**Bulli Seam Operations (MP08_0150)
Water Management Plan**

I refer to the Appin Mine Water Management Plan which was lodged on the Department's Major Projects portal on 21 July 2020.

The Department has reviewed the document and considers that it generally addresses the requirements of condition 16 of Schedule 4 of Project Approval MP08_0150. Accordingly, the Planning Secretary approves the water management plan (Revision 6, dated July 2020).

Figure 1: Appin Mine Water Accounting Framework (Water Balance)

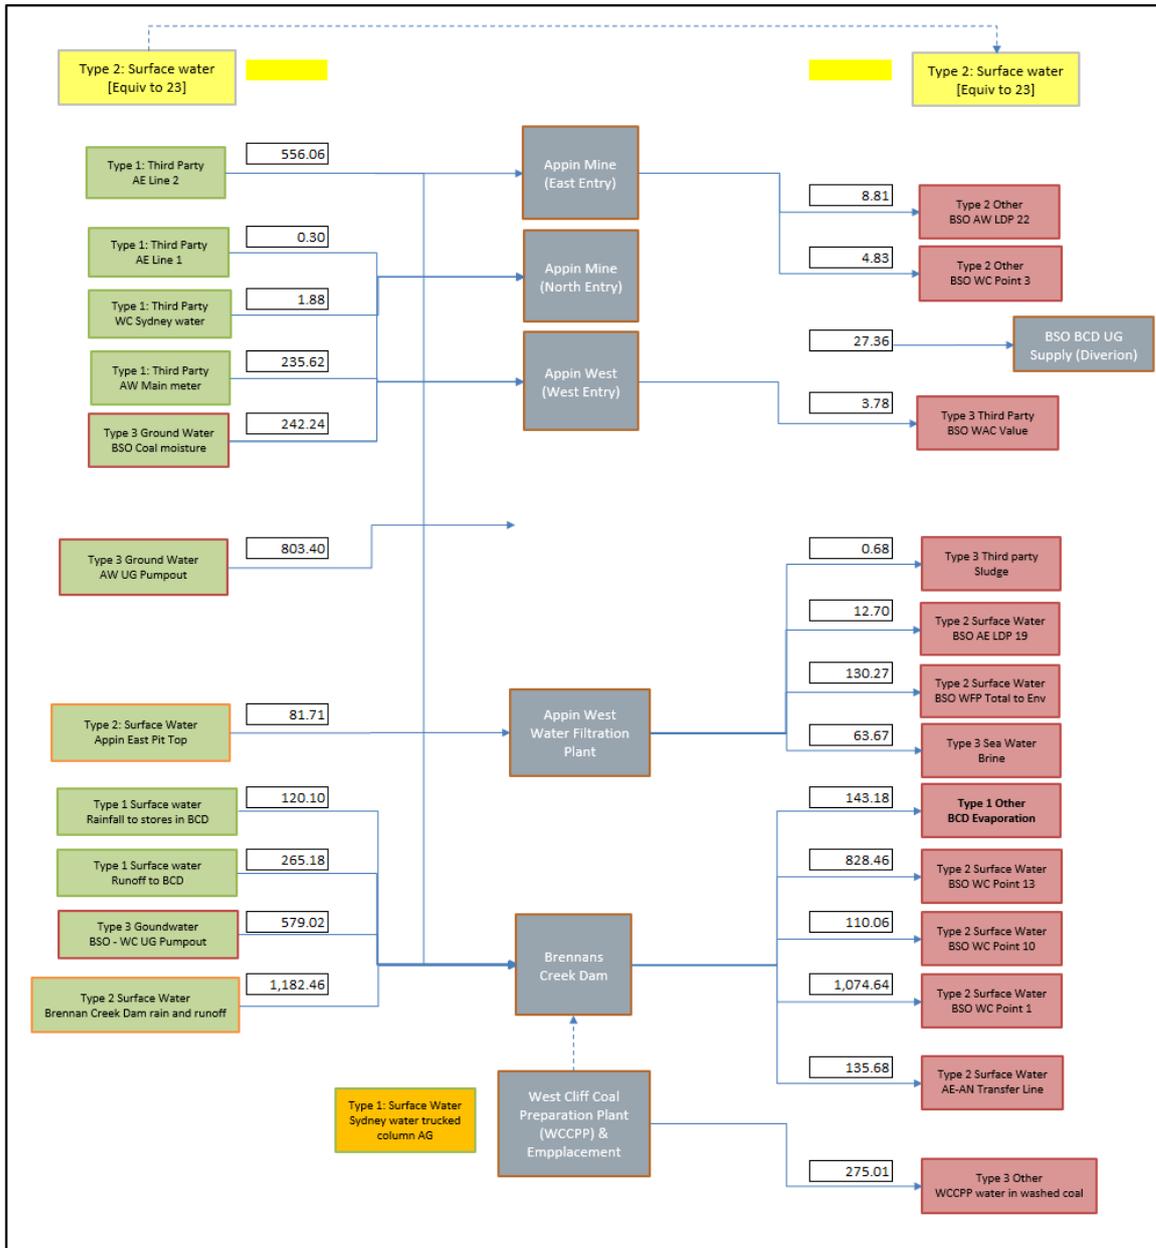
The Department notes that the management plan does not include details about the volume of water that would be treated at the Appin North Water Treatment Plant or the upgraded Appin West Water Treatment Plant, and the water balance does not reflect the changes associated with these plants. The Department also notes the water balance included in the management plan uses data that is three years old, and the plan does not clearly demonstrate the mine's capacity to manage water under all meteorological conditions, including unusually wet or unusually dry years.

The Department also draws your attention to the comments provided by the Natural Resources Regulator (NRAR) on the water balance. The Department concurs with NRAR that the water balance is not particularly easy to interpret, and you should include in the next revision of the management plan a table comparing water inputs, usage and outputs.

The revised management plan should include a water balance based on up-to-date water inputs/outputs, should reflect the changes resulting from the installation/upgrades of the water treatment plants, and should clearly demonstrate the capacity of the mine to manage water under all weather conditions.
